Application for a non-material amendment following a grant of planning permission.

First floor dormer extensions and alterations.	
Reference number:	AW/99/21/HH
Date of decision	14/05/2021

Change in front facing first floor window design.

PROPOSED FIRST FLOOR PLAN

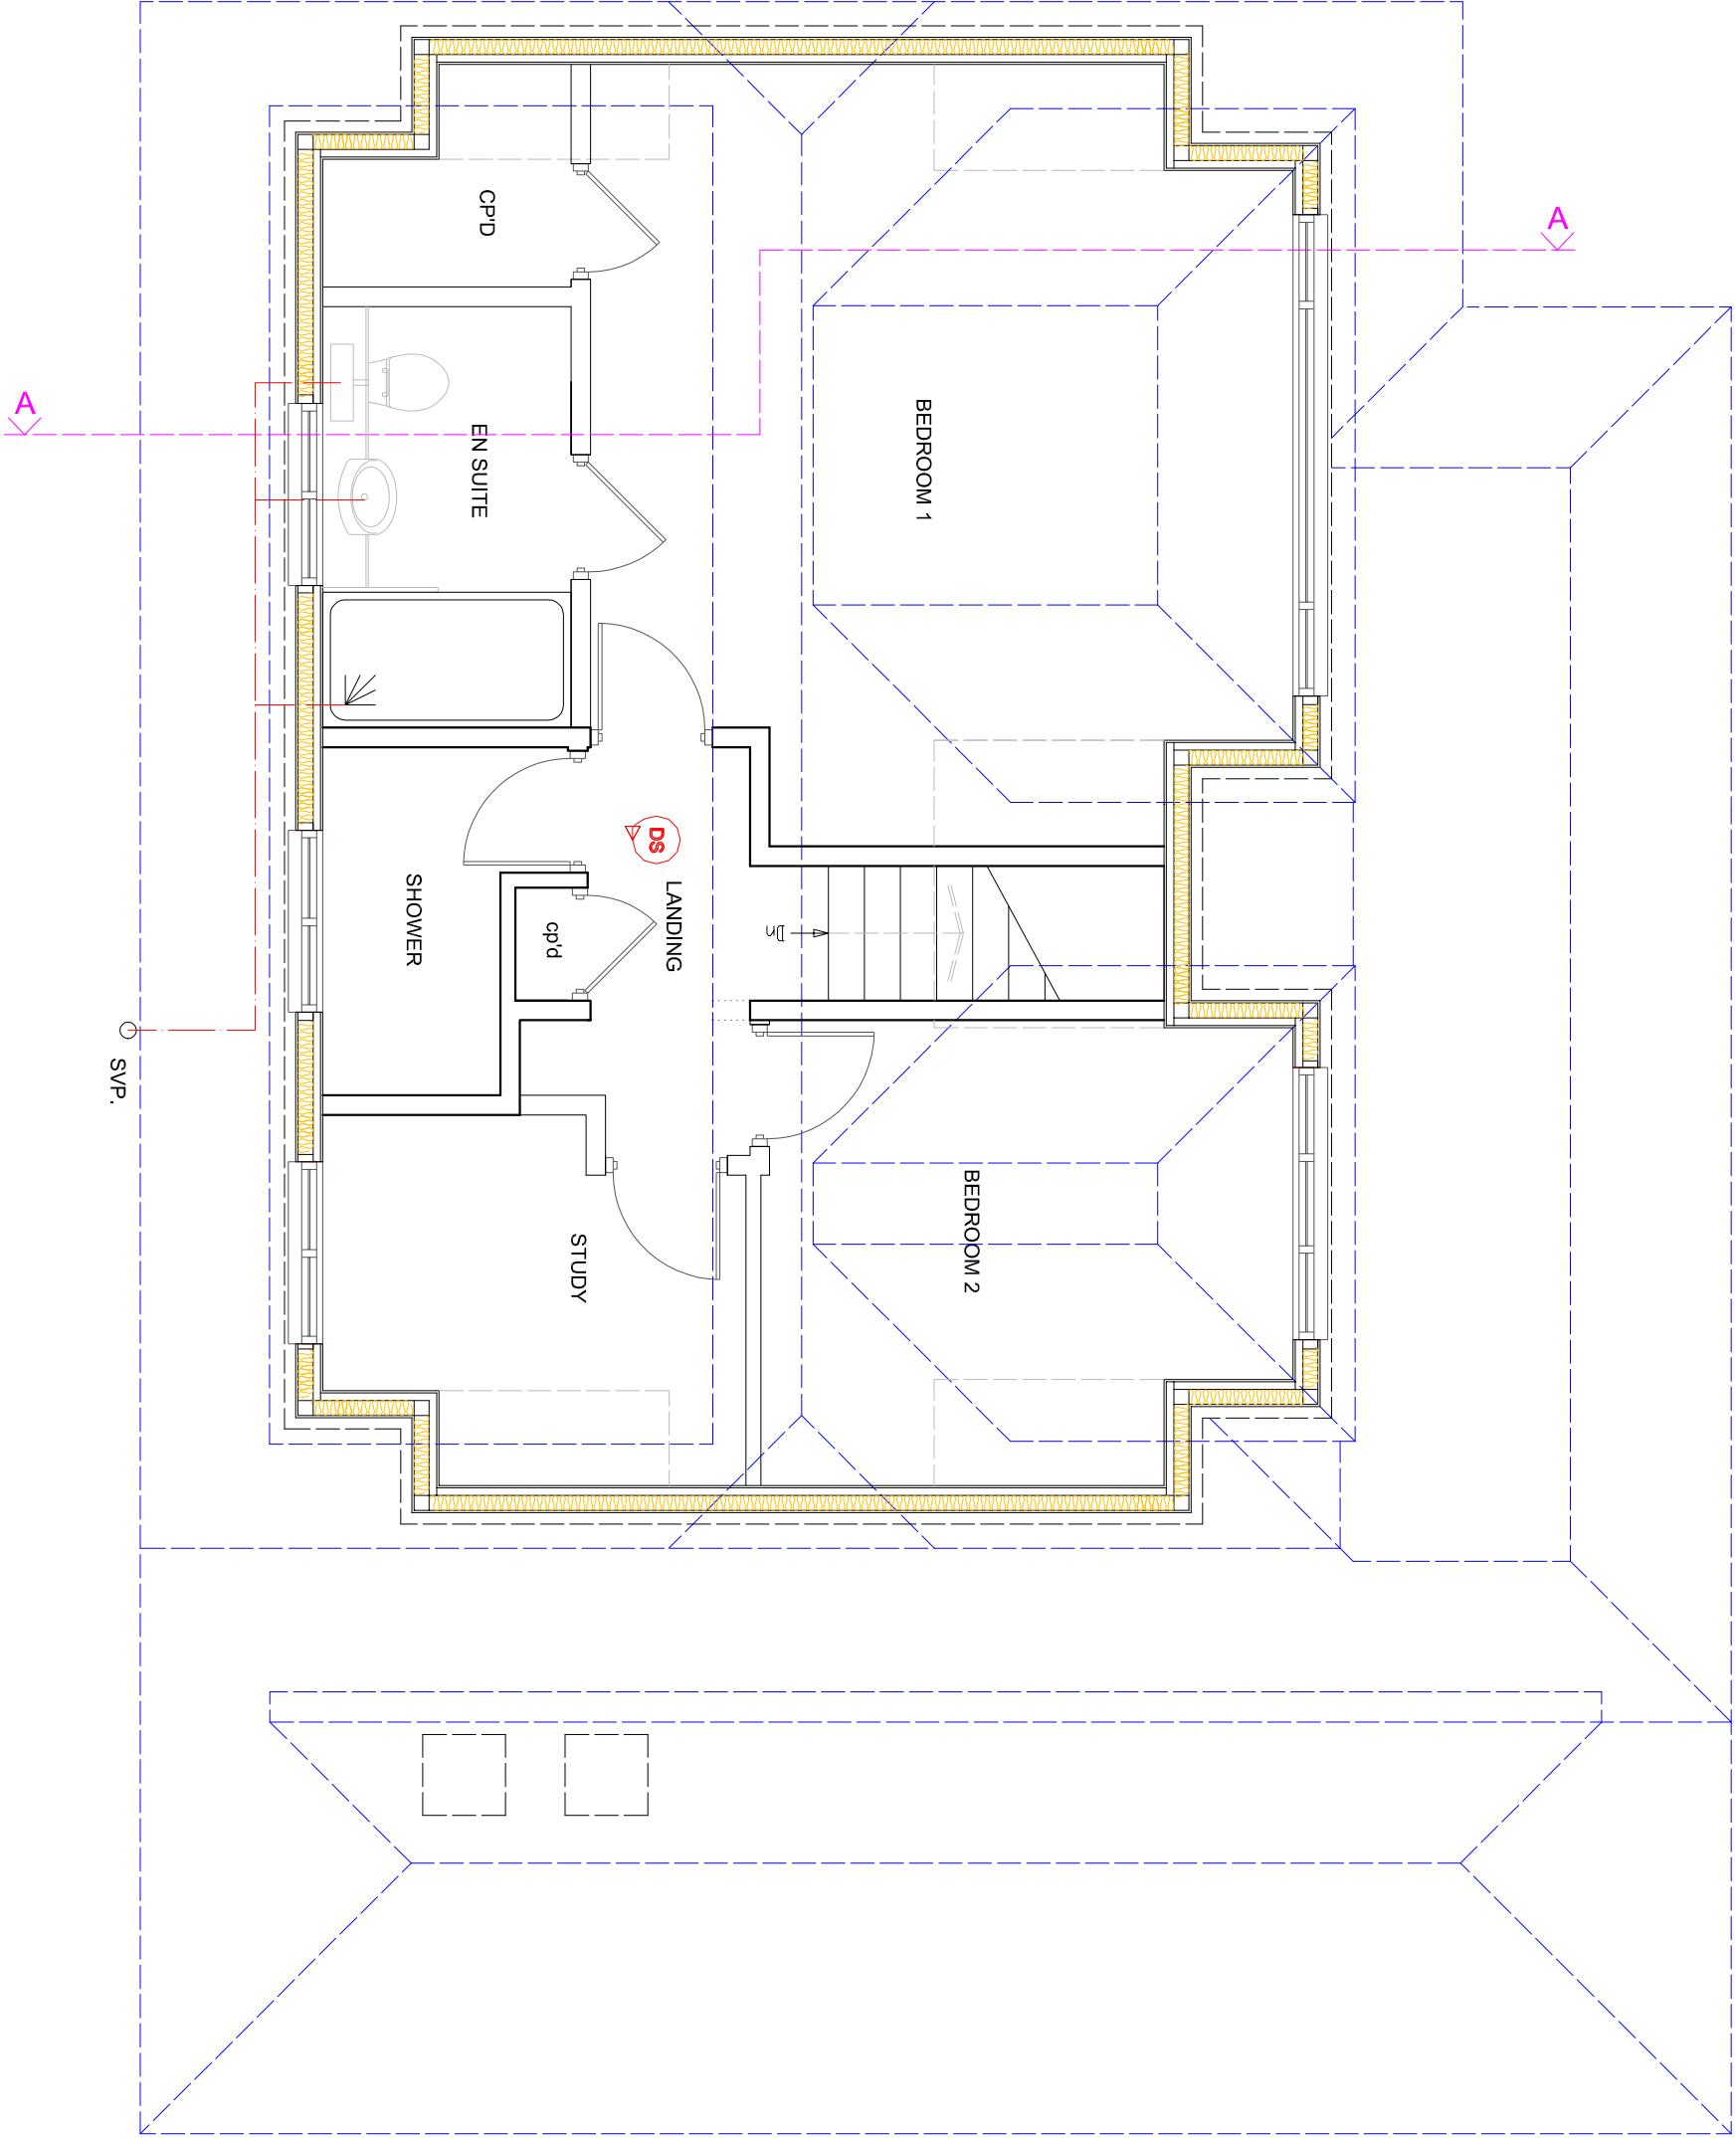
Proposed First Floor Plan 1 - 20/05/2021
Proposed Elevations 1 - 20/05/2021
